Application Reference: 2026/0547

Site Address: 69 Cypress Road, Kendray, Barnsley, S70 3LX

Proposal: Erection of single storey rear extension with a rearward projection of 4.3 m and front porch with access ramp.

DRAWN BY ASAD	CHECKED BY ASAD	DATE 12/05/25
SCALE (@ A1) As indicated	PROJECT NUMBER 097	
DRAWING NUMBER PLD001		REV

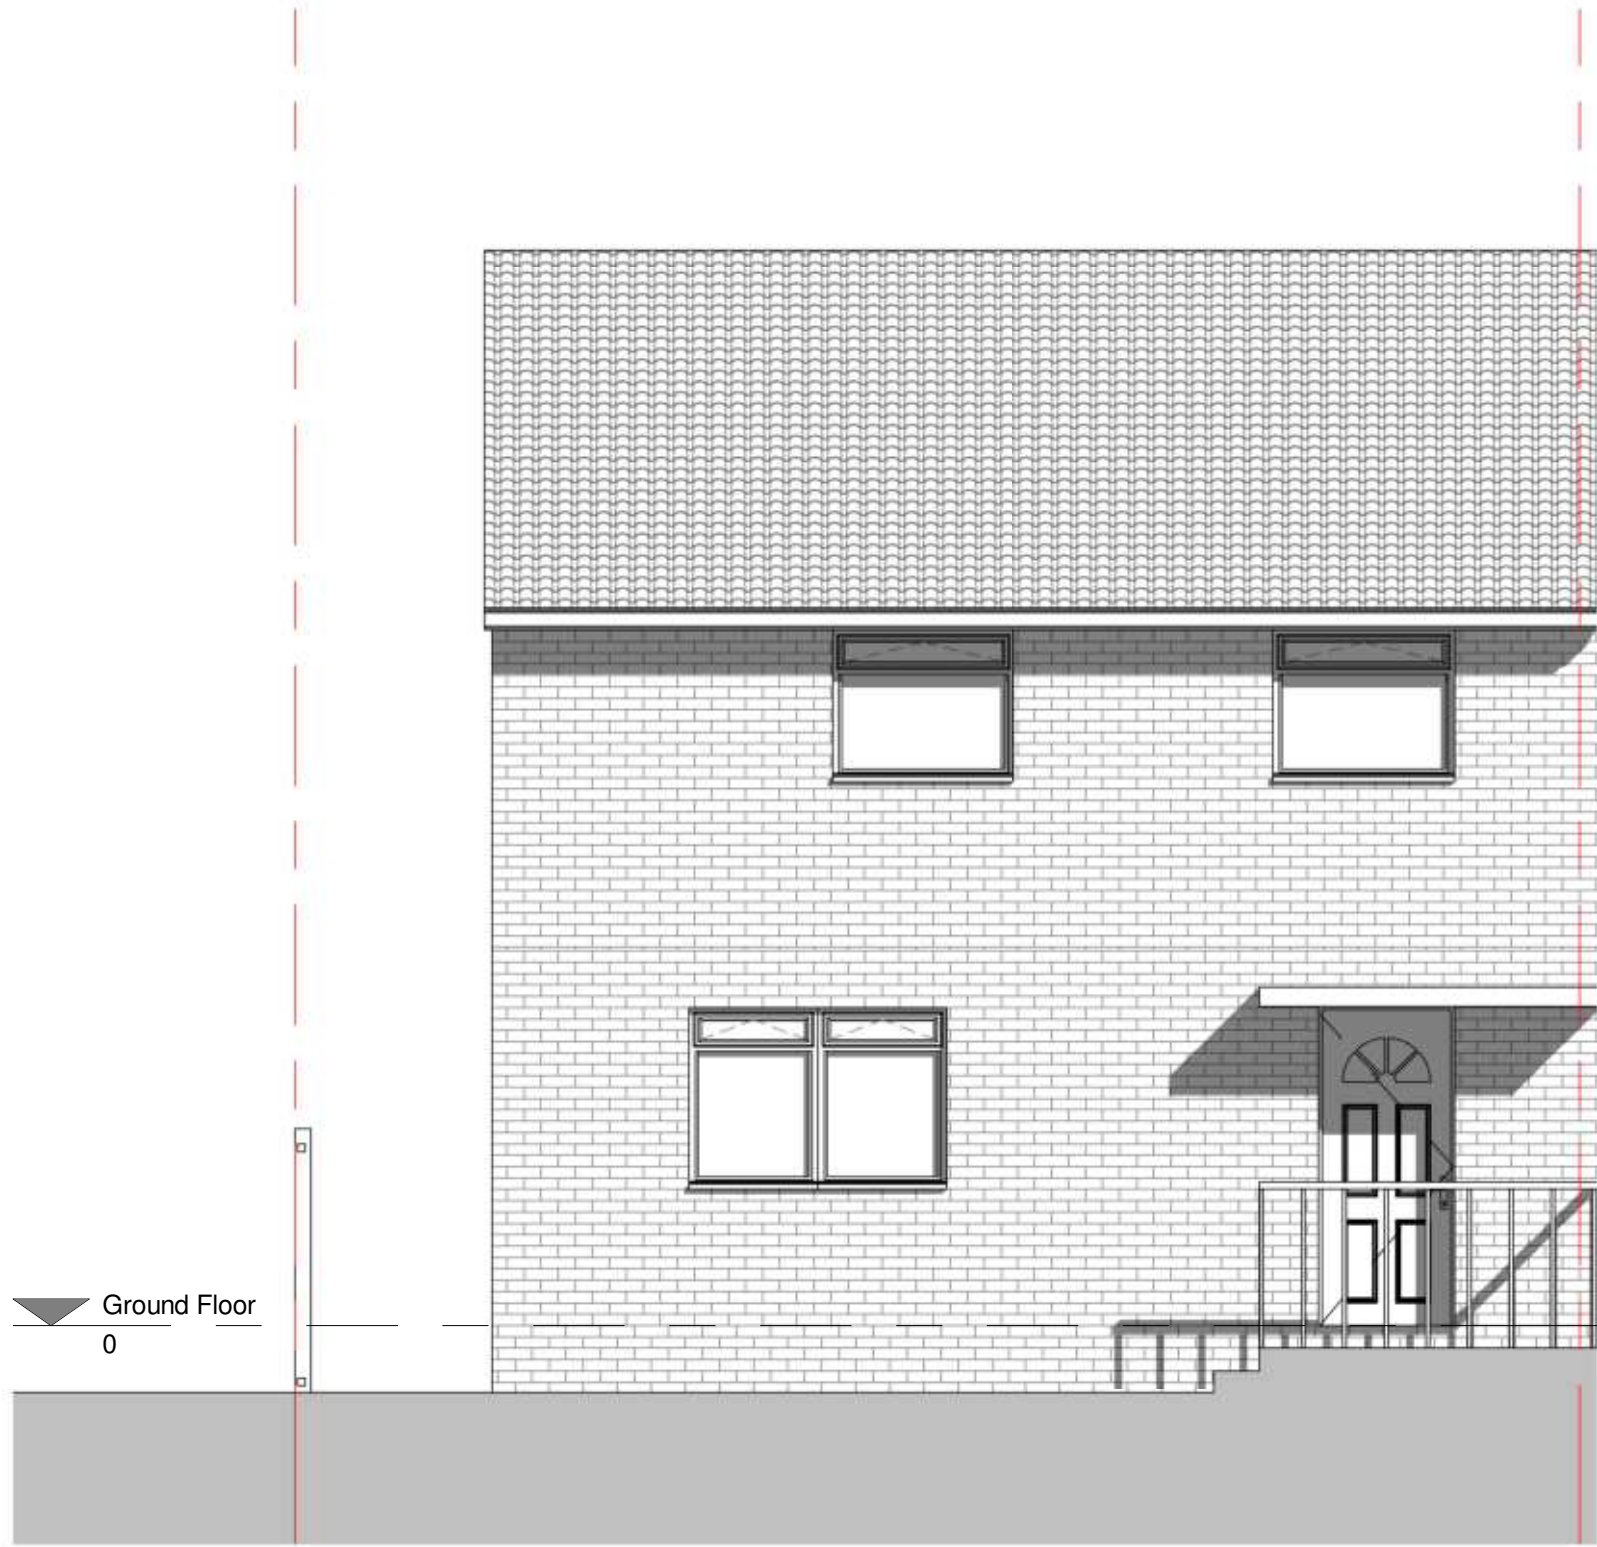
The proposed front extension provides a modest forward projection of 2.3 metres. The site provides a modest front garden resulting in the dwelling being significantly set back from the highway and reducing the impact of the proposed porch on the street scene. A lean-to roof form is proposed which is in keeping with site and the street scene. The proposed location of the front elevation window is welcomed as it assists in replicating the existing location of the front door.

The proposed rear extension would exceed the 4-metre rearward projection guideline outlined within the House Extensions SPD. Given the extension would only exceed the guidelines by 0.3 metres and is located within a large rear garden, the projection of the proposal would be considered acceptable on this occasion. An in keeping lean to roof form has been proposed with a modest eaves and roof height has been proposed at 2.25 metres and 3 metres respectively. The proposed glazing is not considered controversial and is of a similar scale to the existing glazing on the property.

The proposed rear elevation windows to service a Wet Room shall be conditioned to be obscured glazing in order to protect the privacy of the applicant and neighbours.
